Application Reference: 2026/0377

Site Address: Stonehaven, 5 Church Street, Brierley, Barnsley, S72 9JR

Introduction: This application seeks full planning permission for the removal of side conservatory and erection of 2 storey side extension to dwelling

Drawing Title:
**PLANS & ELEVATIONS
 AS PROPOSED**

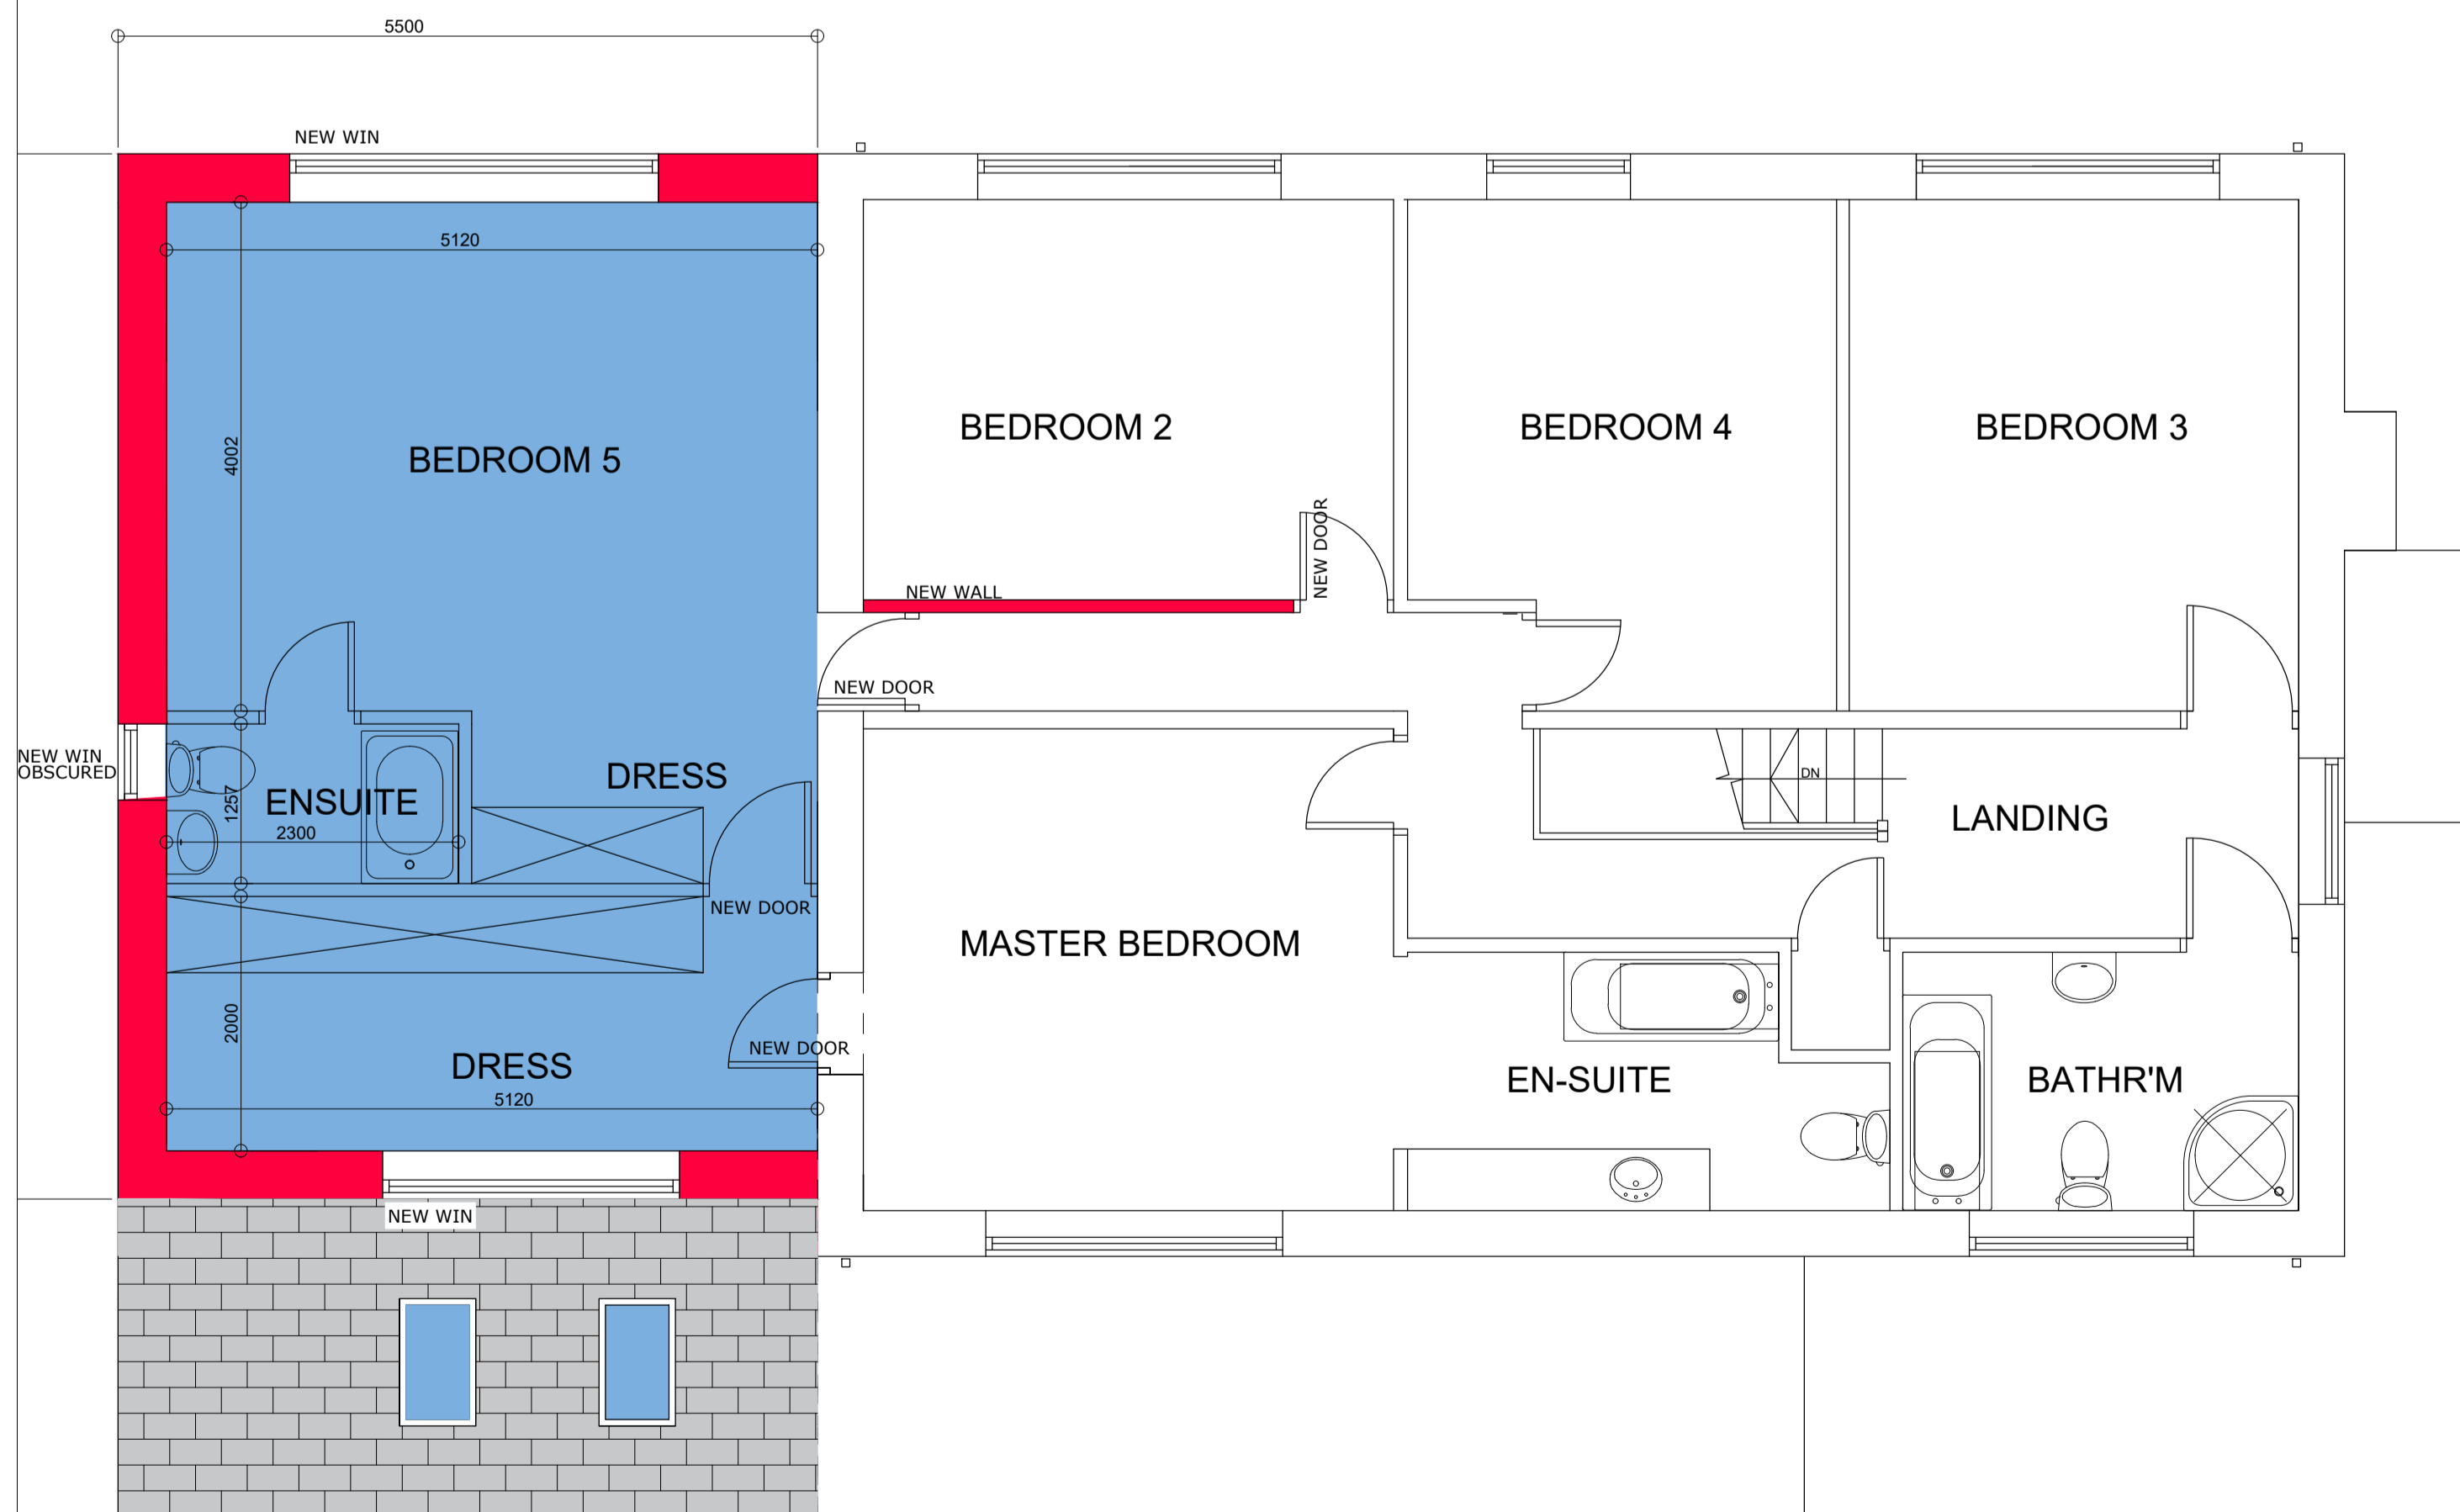
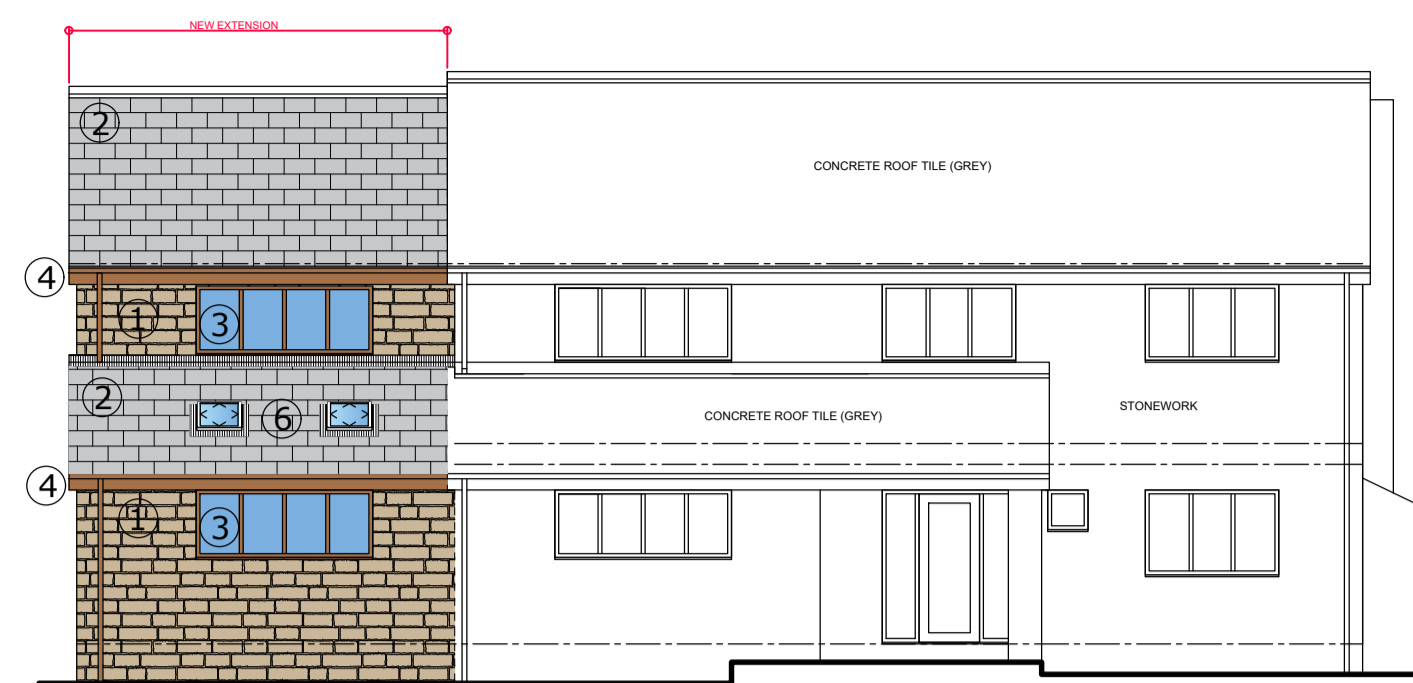
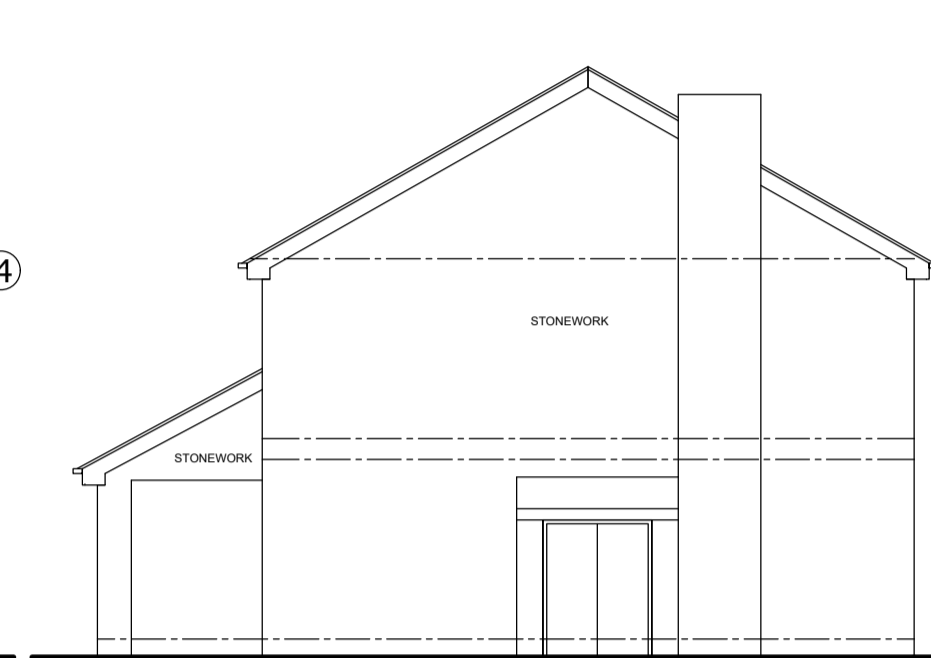
The proposal is a reasonably large side two-story side extension, with an approximate projection of 5m and a length 10.72m, which is the full length of the original side elevation of the dwelling. The proposal would be located on the northern side elevation of the dwelling, replacing an existing white UPVC conservatory. From an approximate existing footprint of 135 sqm, including the conservatory, the proposal would increase the ground floor footprint by approximately 41 sqm to 176 sqm. With a set back of the first floor of the extension proposed, the approximate floorspace would increase by 45 sqm from 104 sqm to 149 sqm. Whilst an 86 sqm increase in floorspace is quite large, it is proportionate to the approximate 239 sqm of the existing dwelling and is spread across two floors.

The local House Extensions and Other Domestic Extensions SPD offers guidance that a side extension should be set back, at least on the first floor of its front elevation, that at least a 1m gap is maintained between its side elevation and the boundary, and that the roof should be stepped down to demonstrate subordination to the host dwelling. In addition to meeting all those requirements, the width of the extension is also less than two thirds the width of the original house, which is a further SPD recommendation.

With the materials proposed to match the existing dwelling, through the use of matching stonework, matching concrete roof tiles, and brown coloured fascia, soffit, drainpipes, and windows, along with new aluminium bi-fold doors, also in a brown colour, the proposal would have little or no impact on the character of the dwelling. When combined with the acceptable scale, and design meeting SPD requirements, the proposal overall would also have little or no impact on the scale, design and character of the dwelling.

3. The external materials shall match those used within the existing dwelling, with specific requirements listed below:-
 - The stonework shall be sandstone and match the existing dwelling in terms of its type, colour, coursing style and face dressing.
 - The roof materials shall match the existing dwelling in type, colour, profile and finish.
 - The windows shall match the existing dwelling in design and colour.
 - The fascia, soffit and rainwater goods shall match the existing dwelling in style and colour.
 - Any new external entrance door shall match the style and colour of the existing doors.
 - The proposed aluminium bi-fold door, in a brown colour to match the existing windows is acceptable.
 - The proposed roof lights should be specific conservation style rooflights.

SIDE ELEVATION (N) SCALE 1:100

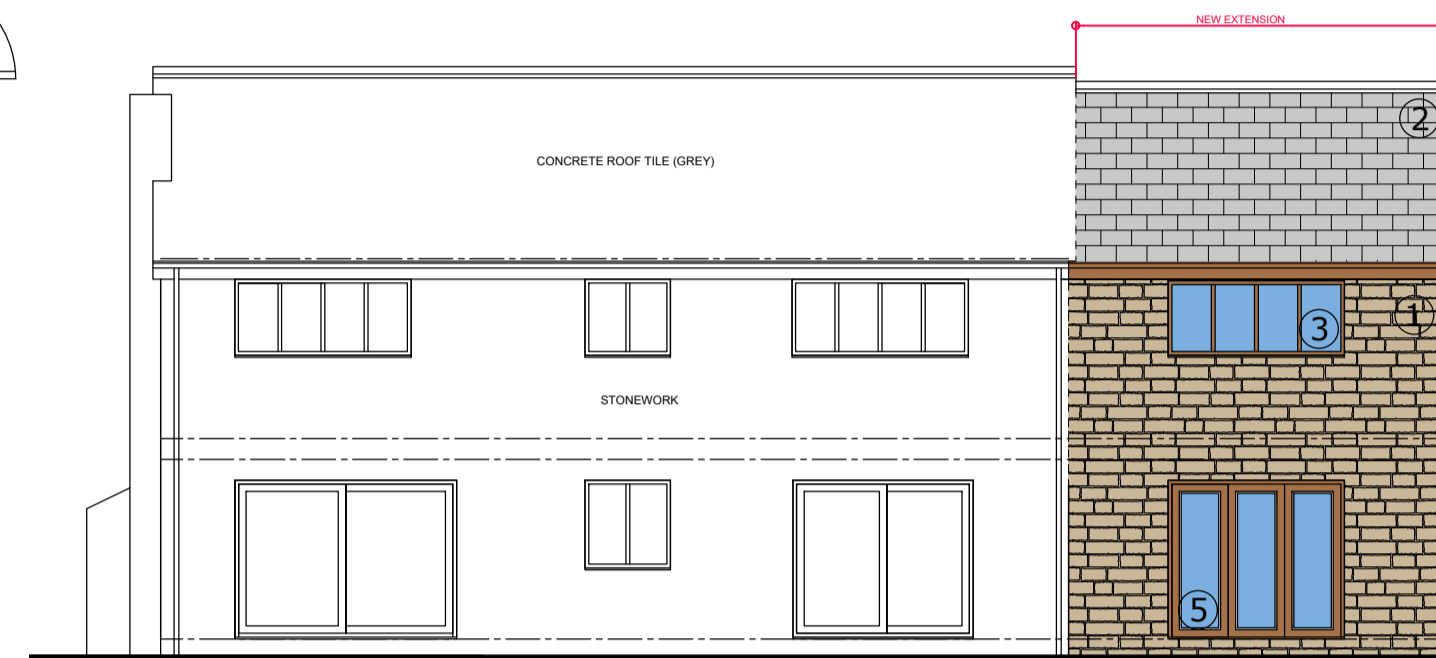
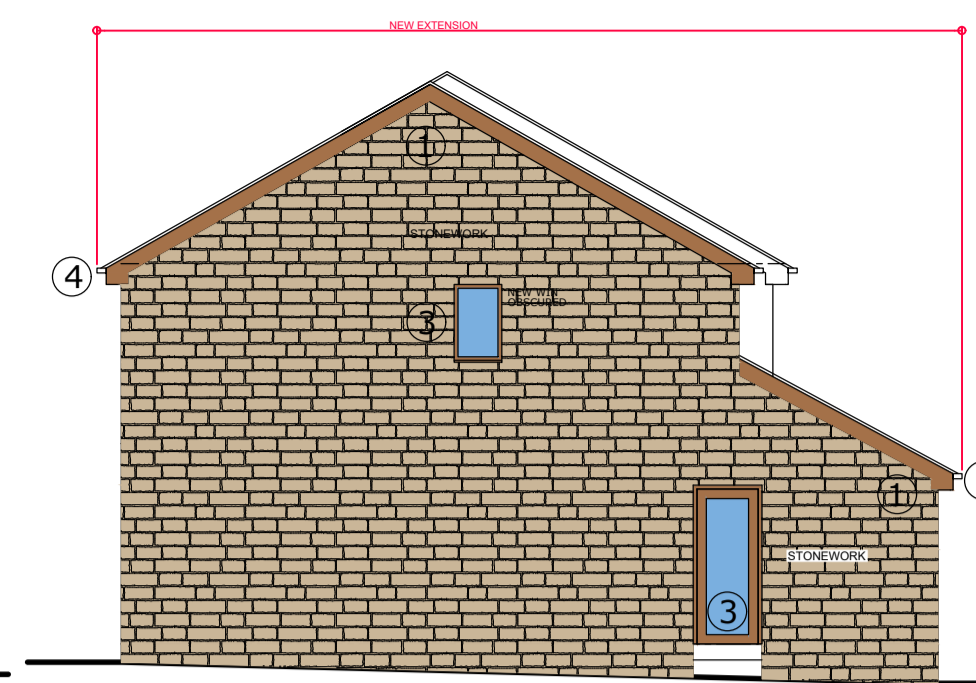
The three dwellings which may experience some impacts are Nos 9 – 13 Haldane Close, particularly No 11 whose rear gardens backs on to the northern boundary of the application dwelling, where the proposed extension would be sited. The proposed extension would be approximately 0.45m closer to the boundary than the conservatory, at 3.95m, but would also feature a much longer length and height. A door at ground floor, and a first-floor en-suite window are proposed within the extension. The ensuite window would feature obscure glazing and would have a condition to ensure this remains. In contrast the ground floor door is to a utility room, so would pose less harm than the current glazed conservatory.

With the impact on overshadowing not being a issue for the potentially most affected neighbouring dwelling of No 11, and the proposal not directly overlooking other neighbouring dwellings or their gardens, the potential impact of the proposal would be limited to potential overbearing. Starting with No 11 again, with an approximately 3.95m between the extension and their rear garden, and approximately 12.3m between the extension and their rear elevation (which complies with the separation distance set within the SPD), whilst the extension would be clearly noticeable, it would only be likely to have, at most a modest impact on their amenity. No 13 is located further away than No 11, and is not directly next to the proposed extension, so any impact would be considered as little or none.

4. The first-floor window on the northern elevation of the extension facing Haldane Close shall at all times be fitted with obscure glass to Pilkington Level 3 obscurity or equivalent and retained as such thereafter.
